Thank you for inviting the Lead Local Flood Authority (LLFA) to comment on the below application.

PLANNING APPLICATION CONSULTATION RESPONSE

Application Number:	3/2021/0793
Location:	Coars Farm, Settle Road, Skipton
Proposal:	15 Holiday Chalets, conversion of existing holiday house and adjacent barn to 20-person holiday let. Extension of Café, construction of reception and managers flat, alter garden centre to farm shop with plant display, creation of carpark.

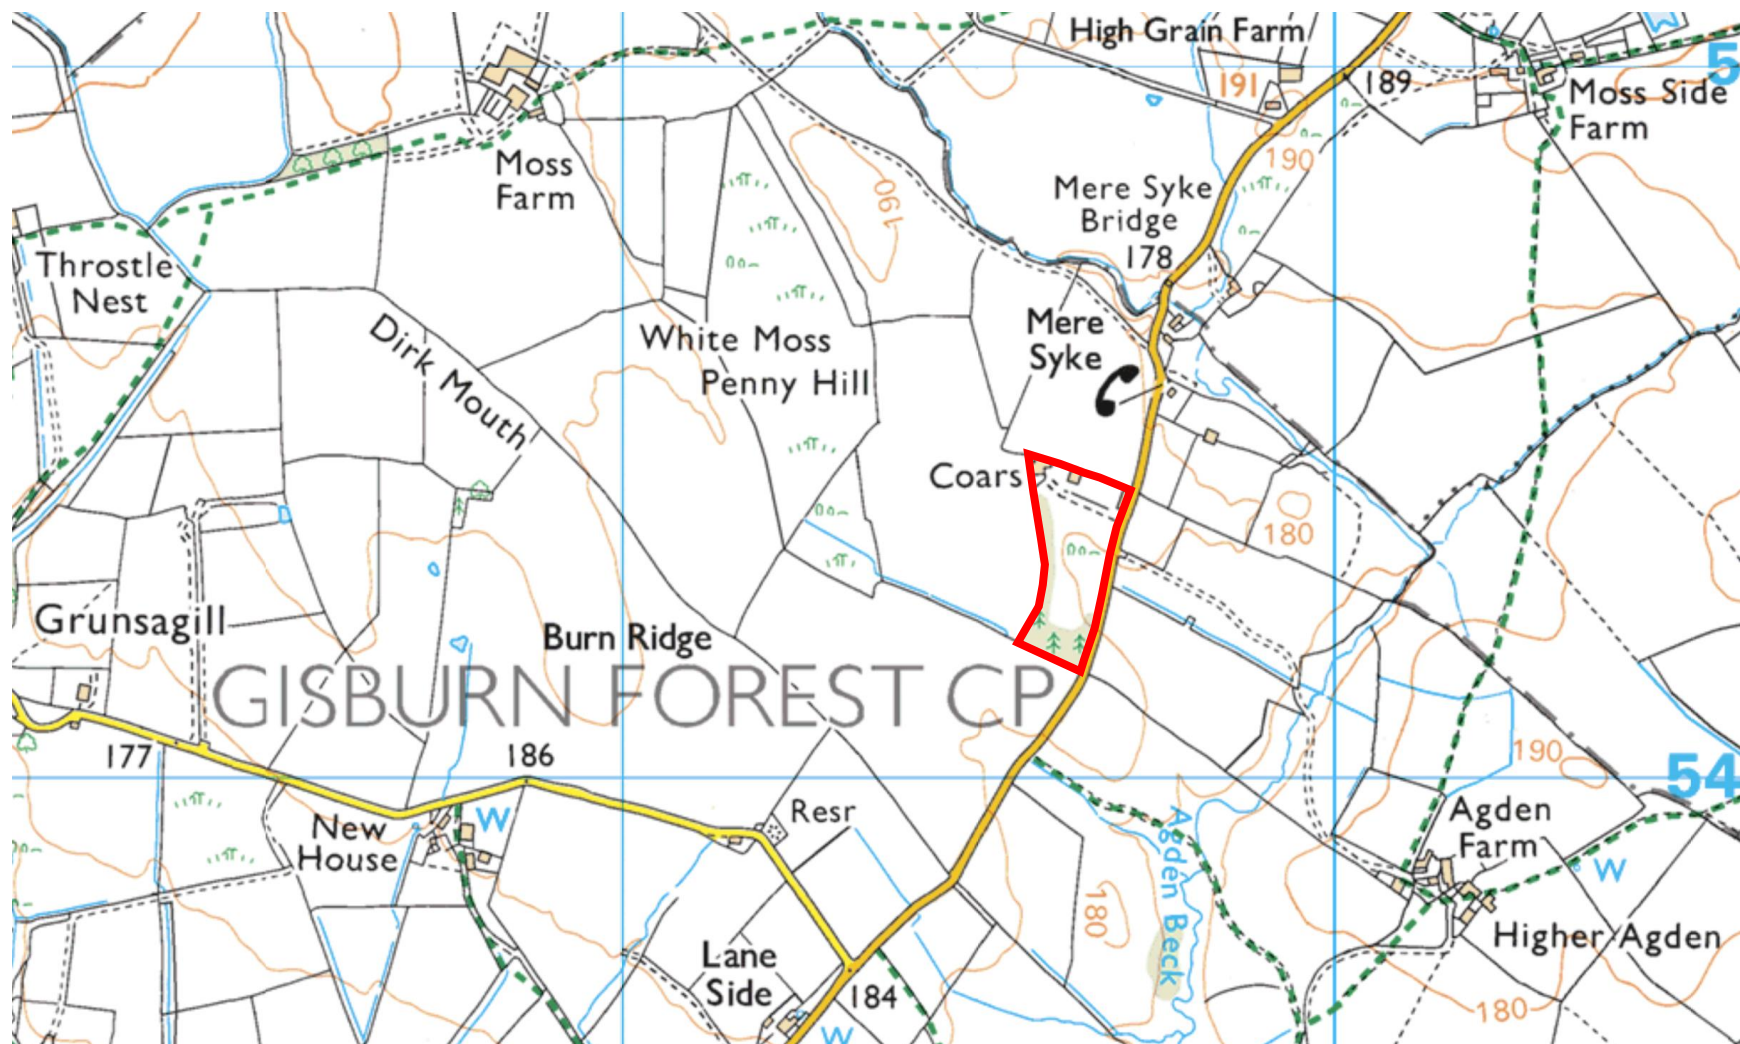
The proposals indicate that the applicant intends to discharge treated foul water from the proposed package treatment plant into the watercourse to the west of the site.
